January 6, 2026

REQUEST

Approximately 1.14 ~~1.49~~ acres located north of Cleveland Avenue, west of East Worthington Avenue, and east of South Boulevard.

SUMMARY OF PETITION

RZ-2

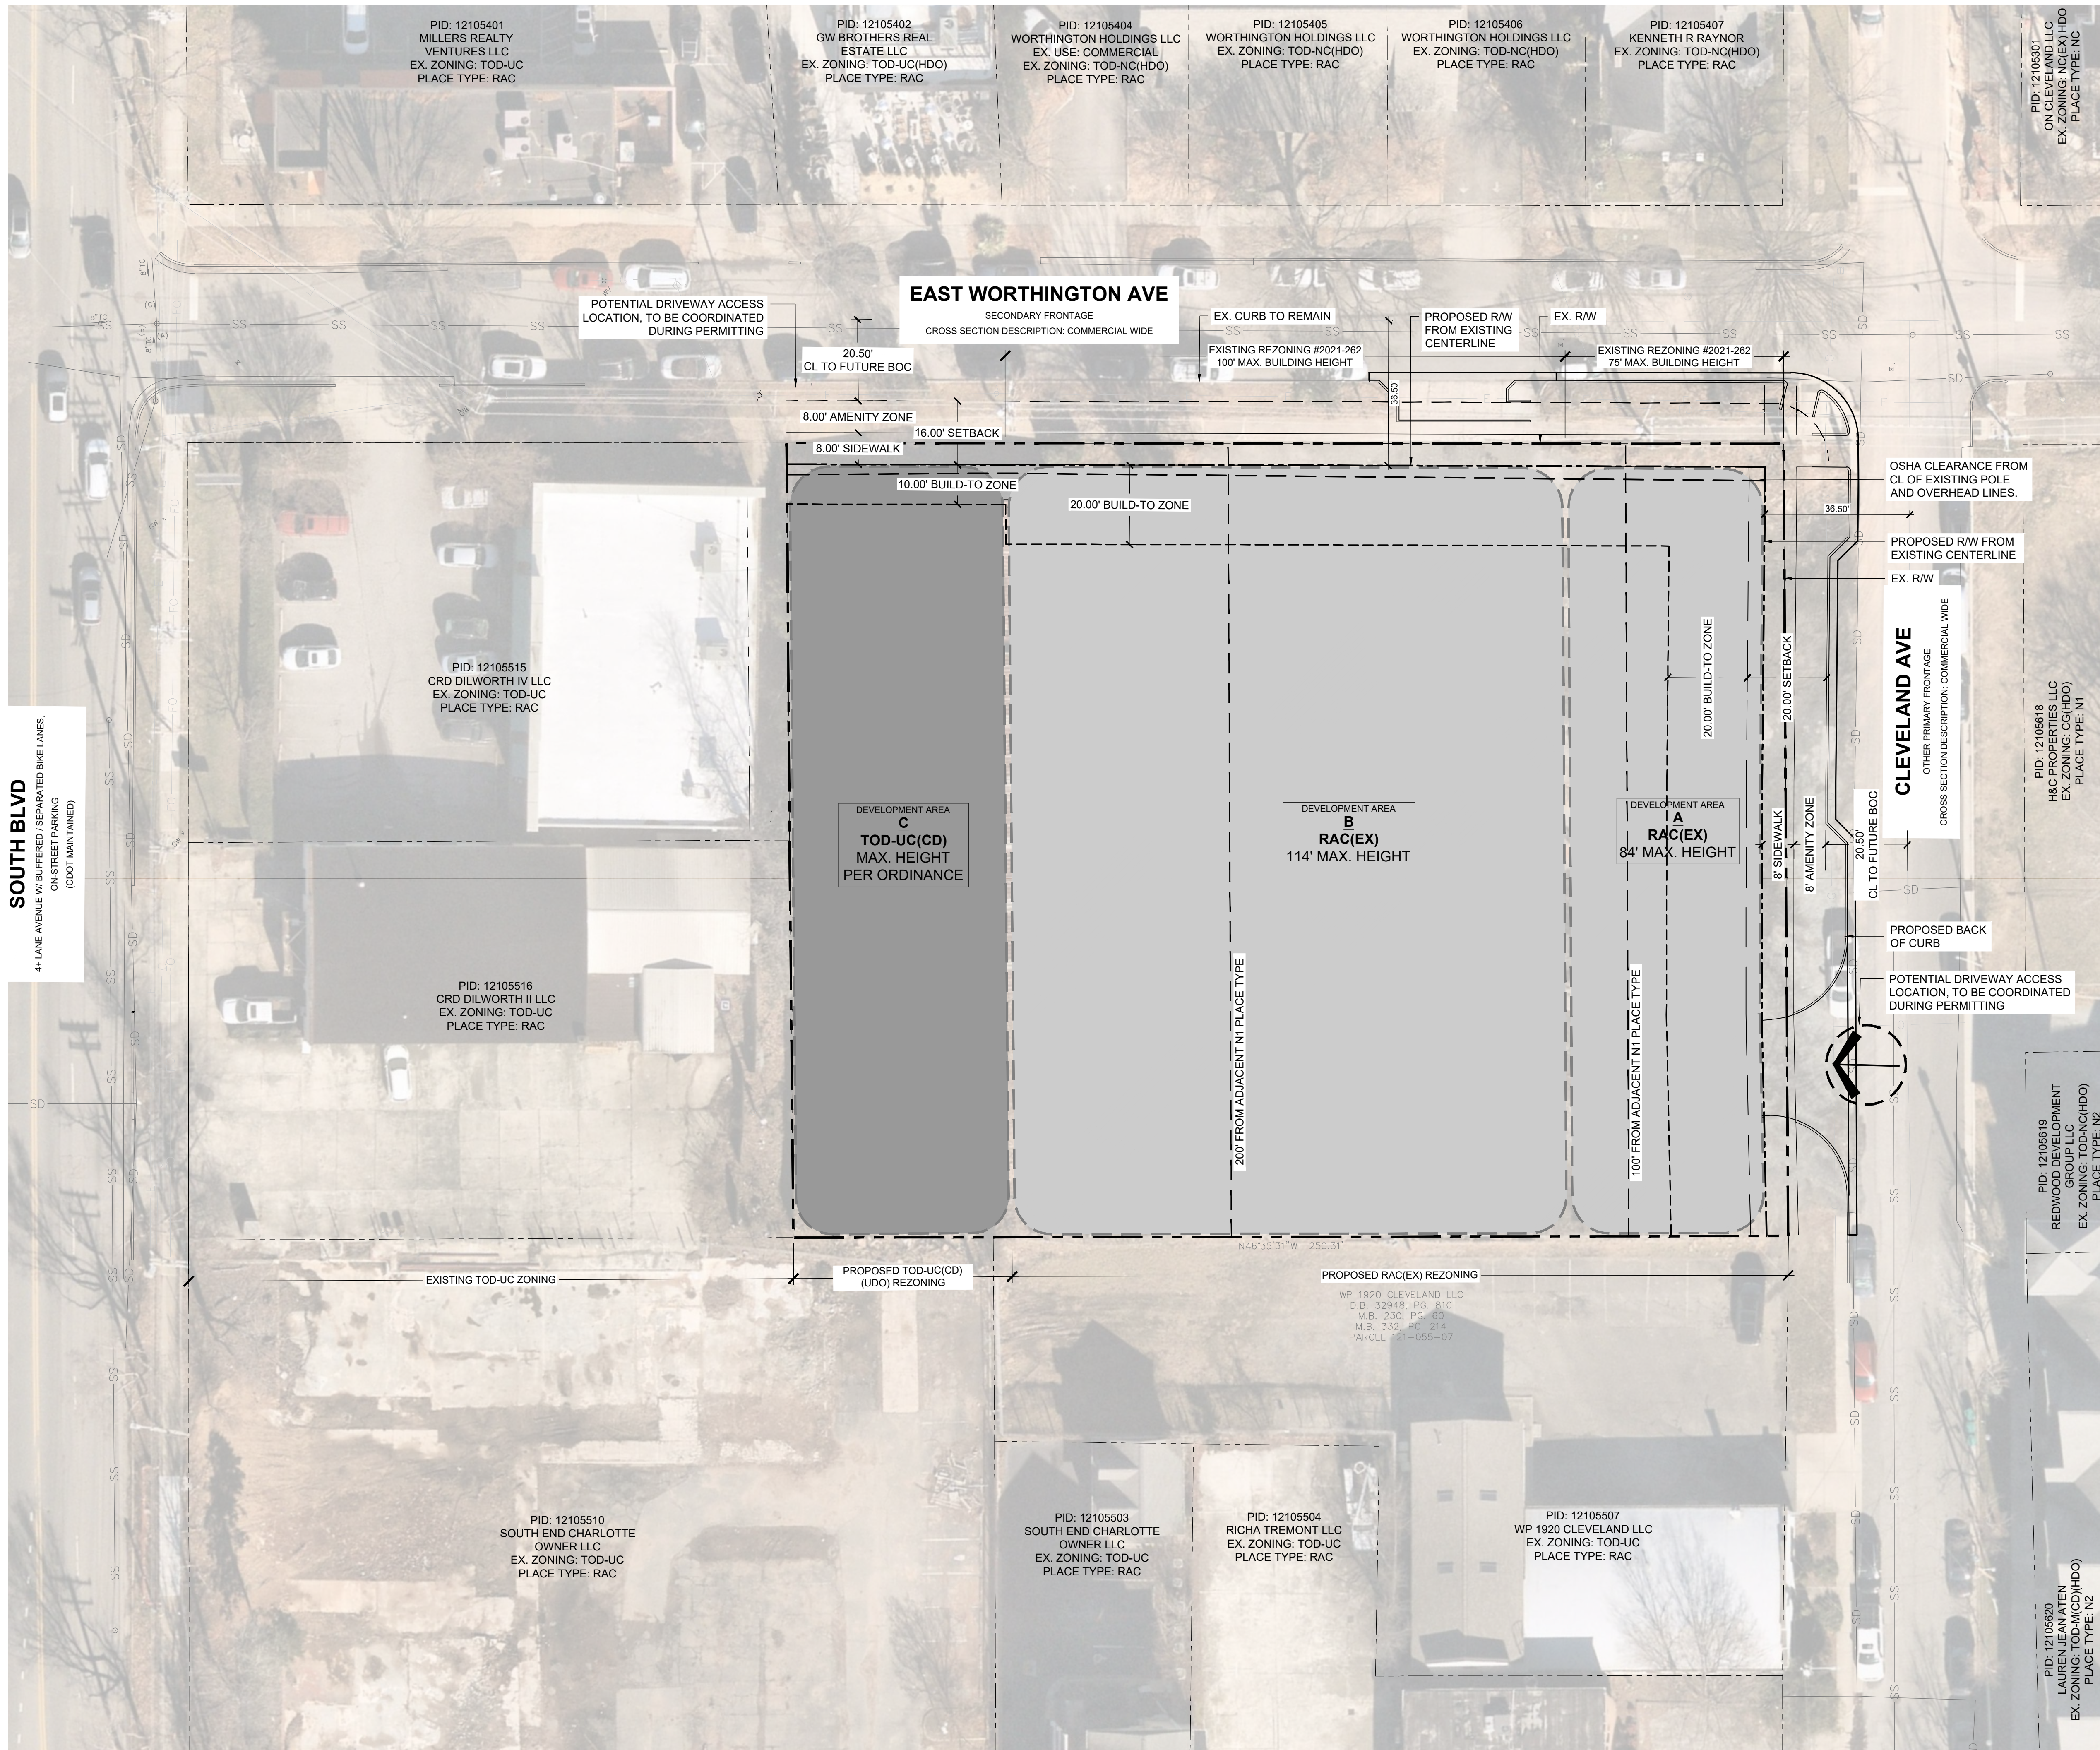
1. ~~CDOT: Add a conditional note specifying "the Petitioner shall dedicate and convey in fee simple all rights of way to the City before the site's first building certificate of occupancy is issued. CDOT requests rights of way set at 2' behind back of sidewalk where feasible."~~ Addressed
2. CDOT: Revise site plan and conditional note(s) to commit to the removal of shown potential site access off Worthington Avenue.
3. ~~CDOT: Revise conditional notes to match project's proposed uses with the approved TIS.~~ Addressed

4. Entitlement Services: The TIS for the site specifies a hotel use. The conditional notes should clearly state that the primary use on the site.
5. ~~Entitlement Services: Continue negotiations with community to finalize Exception (EX) benefits.~~ Addressed

7. Entitlement Services: Revise the proposed City Improvement EX benefit so that it may be enforceable during permitting stages.
